EPA Response to MOD 2 - Integrated Water and Leachate Plant Modifications

Thank you for consulting with the Environment Protection Authority (EPA) regarding Modification Application for an integrated water and leachate plant modification (PAE-53640707) at Orchard Hills Waste Facility (Patons Lane Resource Recovery Centre) (Lot 40, DP 738126) located at 123-179 Patons Lane, Orchard Hills (the Premises).

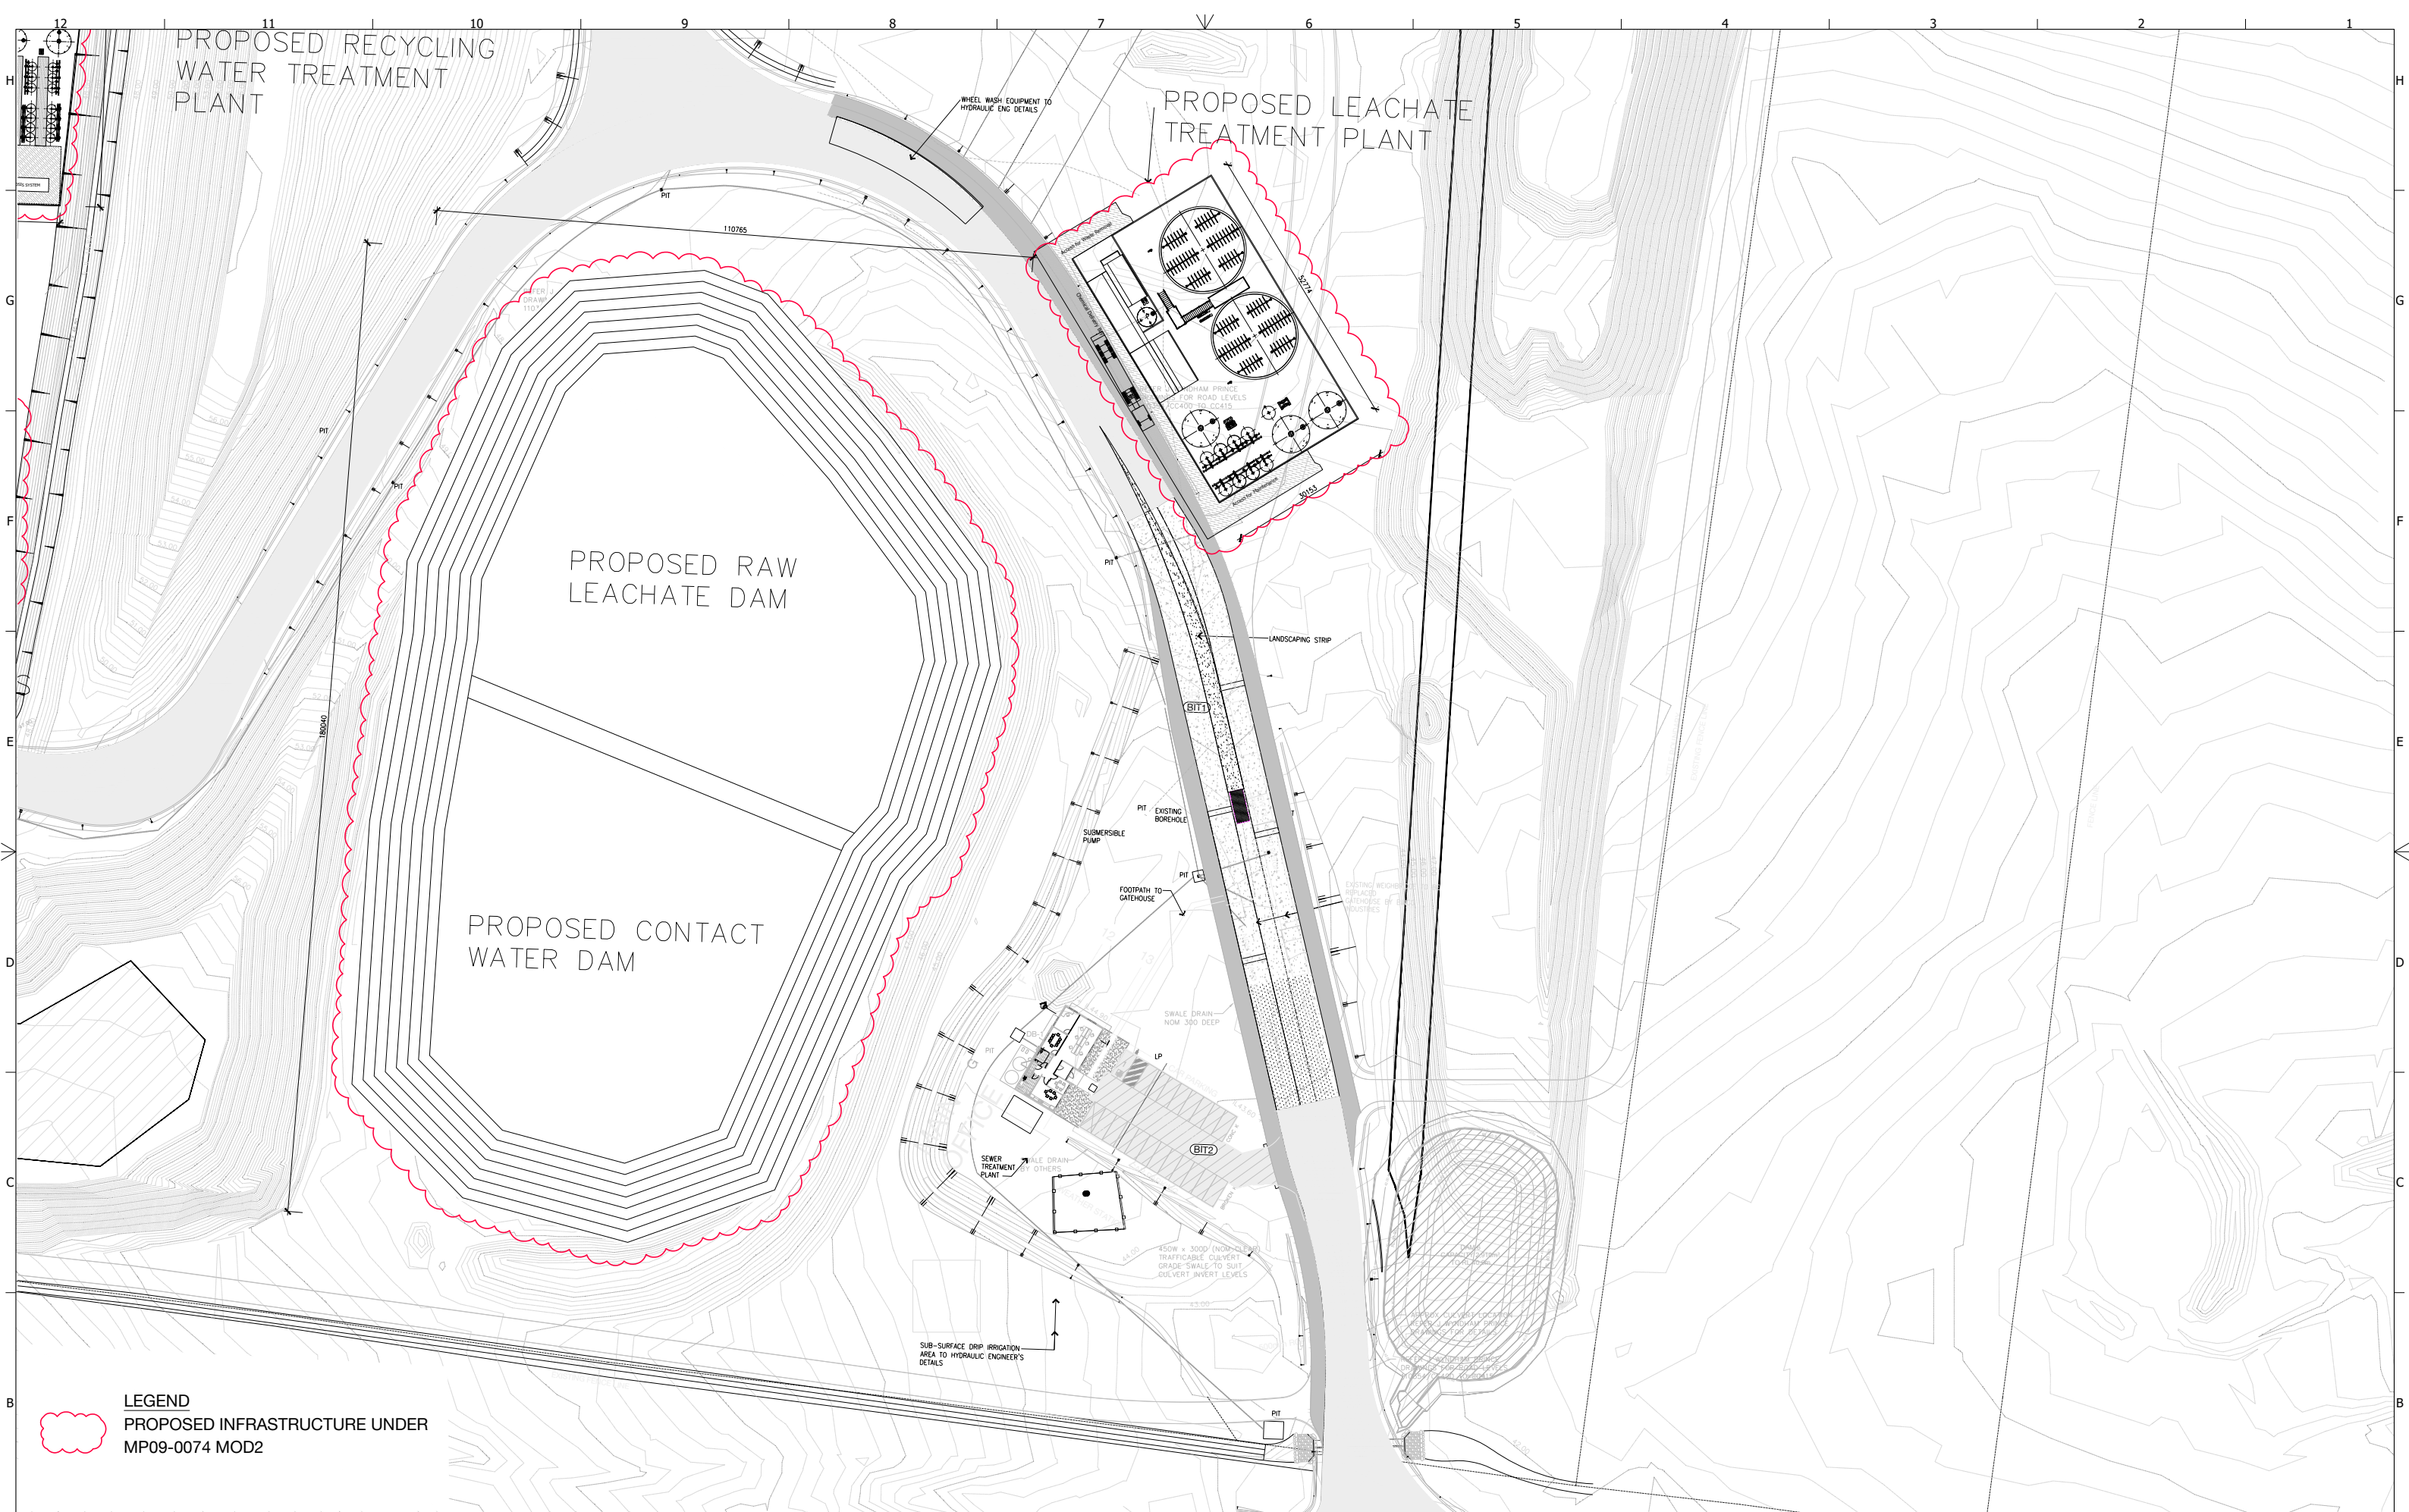
In the Modification supporting documentation 'Patons Lane Resource Recovery Centre –Integrated Water and Leachate Plant Modifications – Modification Report SRC Operations, (Jackson Environment and Planning Pty Ltd, December 2022) it refers to a *Leachate Water Balance Assessment*, GHD (2022) that includes details of the site leachate management system water balance. This document was not available to the EPA for review. Therefore, the overflow point(s) for the leachate system, overflow conditions and frequency are unclear.

- a) Further information is required on managed overflows that may occur from the leachate/contact water systems, including impacts of the proposed changes to the system, overflow discharge points and receiving environments, overflow frequency, design rainfall event that would cause overflow, and compliance with the EPA Landfill Guidelines related to provisions for managed overflows of leachate.

From the Soil and Water Assessment it demonstrated that Dam 2 in the stormwater system had a maximum value of 10 mg/L of ammonia for the monitoring period 19 September 2019 and 6 October 2022. The source of this ammonia is unclear however it could be related to overflows from the leachate management system.

- a) Clarification that no overflows into the site stormwater management system will occur, in the context of high levels of ammonia detected in Dam 2 in recent monitoring.
